Observations By:	KC, Lead Local Flood Authority
Application No.	2021/91728
Proposed Development:	Discharge of conditions 10 (estate roads), 11 (access split), 12 (drainage), 17 (public rights of way), 18 (ecological impact), 21 (coal mining legacy) and 26 (secure by design) of previous permission 2020/94202 for variation of Conditions 1, 9, 19, 28 on the previous outline permission 2018/94189 (outline application for residential development of up to 366 dwellings with details of access points only) to allow for minor changes to the red line boundary plan and minor variations to the approved southern highways access point and approved remediation strategy specifications
Location:	Land Off, Soothill Lane, Batley
OS Map Reference	SE 425889.2804 423991.6715
Applicant/Agent:	Keepmoat Homes
Class:	No Required

Consultation Response from KC, Lead Local Flood Authority		
2021/91728 Land Off, Soothill Lane, Batley		
Discharge of conditions 10 (estate roads), 11 (access split), 12 (drainage), 17 (public rights of way), 18 (ecological impact), 21 (coal mining legacy) and 26 (secure by design) of previous permission 2020/94202 for variation of Conditions 1, 9, 19, 28 on the previous outline pe

General Arrangement 5 of 6
StormTank MPS
36.5m x 20.725m x 2.8m

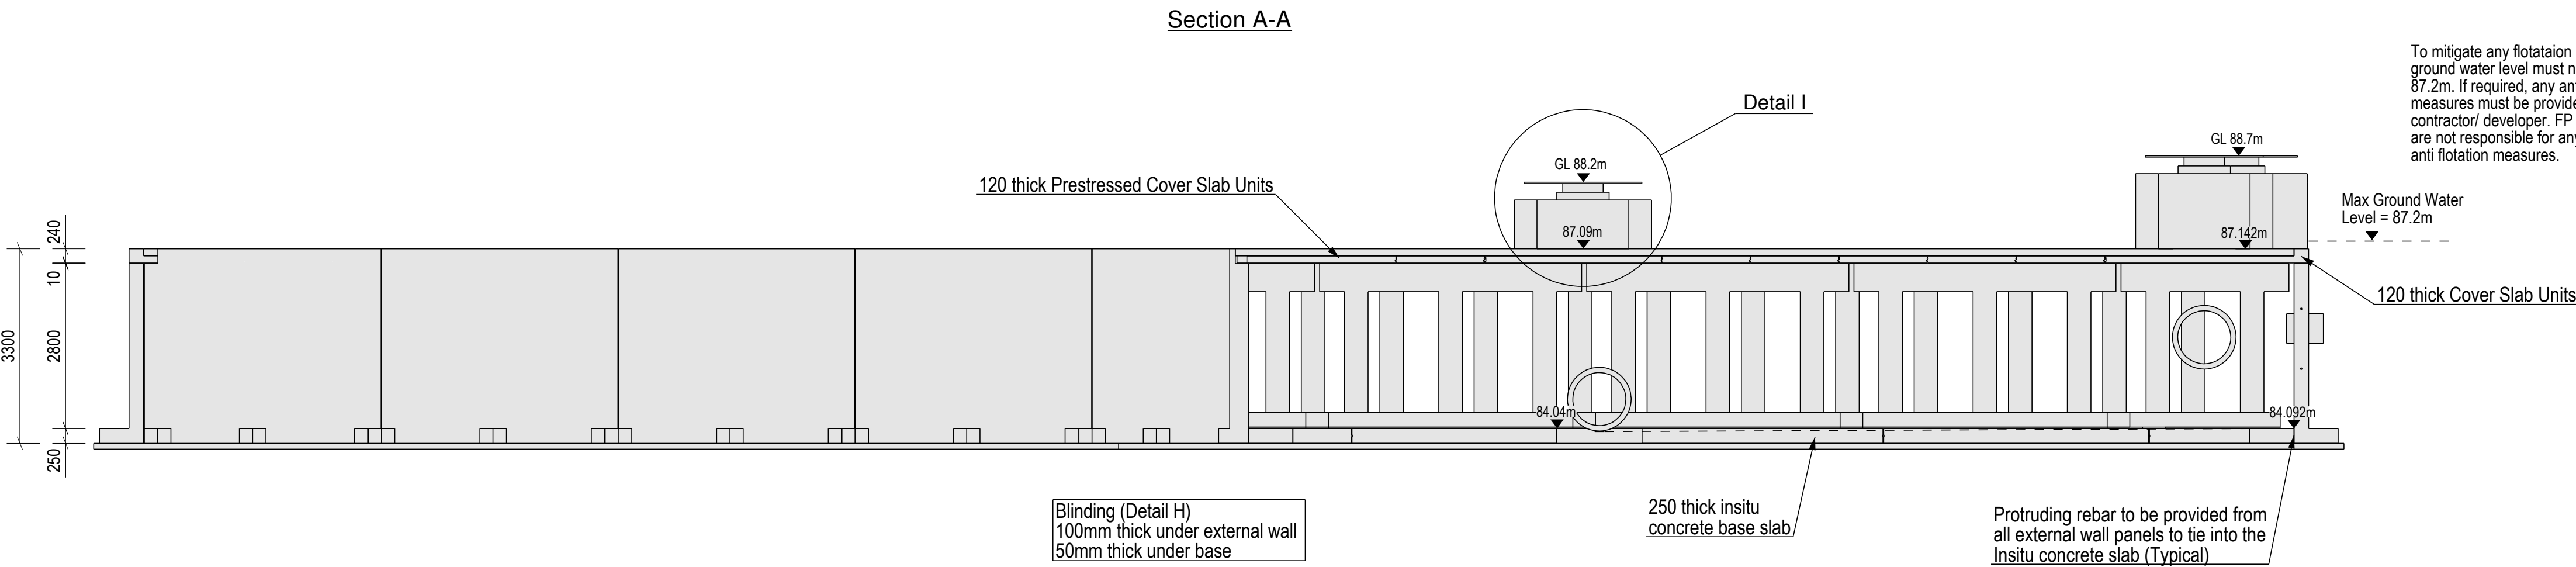
Several Tank Drawings shown as requested and include volume defined by manufacturer FPMcCann. This can go forward to be assessed alongside microdrainage calculations for part c of condition 12.
